Re: Uungula Wind Farm (SSD6687) Clarifications During Recommendation Period

CWP Renewables Pty Ltd (CWPR) on behalf of Uungula Wind Farm Pty Ltd (UWF) is providing this letter for clarification on two subjects within the Recommended Development Consent and Assessment Report for the Uungula Wind Farm project (SSD6687).

APPENDIX 6 HERITAGE ITEMS

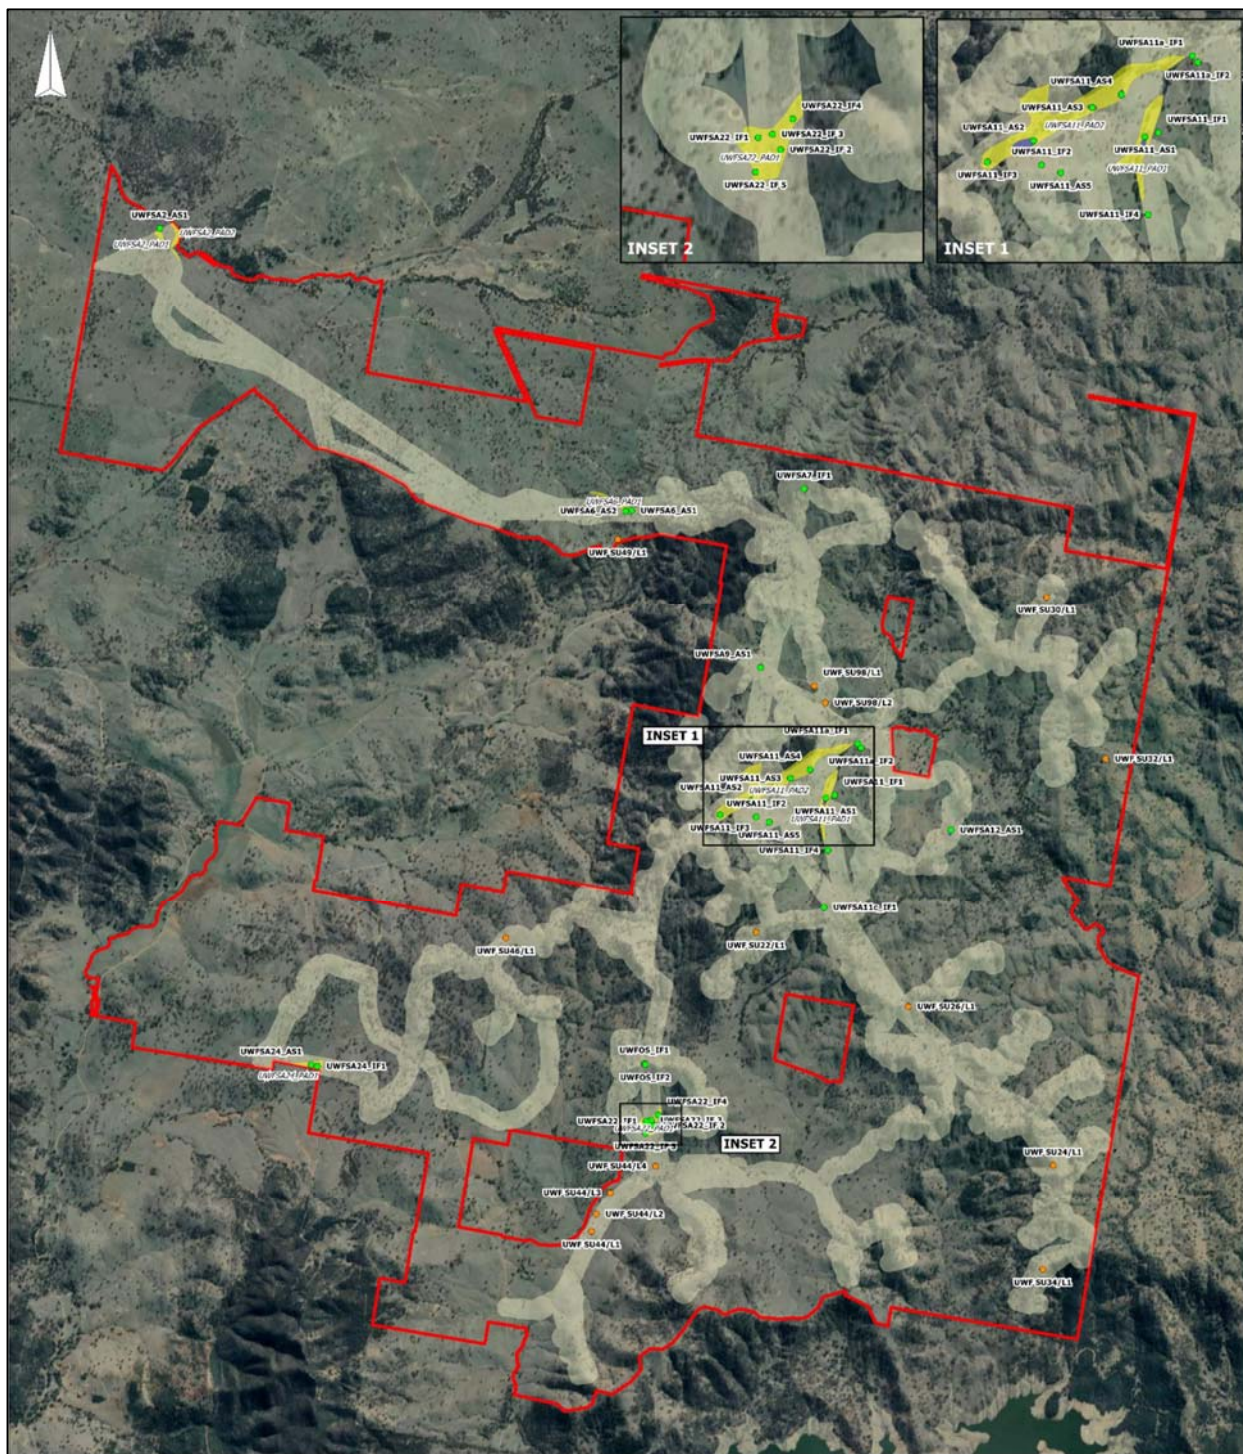
Upon review of the Heritage artefacts stated in Table 2 of Appendix 6 of the Development Consent it was identified there were two Items missing which should be added. The two were recommended for salvage (labels UWF SU98/L1 and UWF SU98/L2) in the NSW Archaeology Aboriginal Cultural Heritage Assessment Report (Appendix K to the EIS) (page 189) in the statement "It is recommended that a program of archaeological salvage excavation in Survey Unit 98 could be an appropriate form of impact mitigation for Aboriginal cultural values.". Those have been added to an updated figure included below.
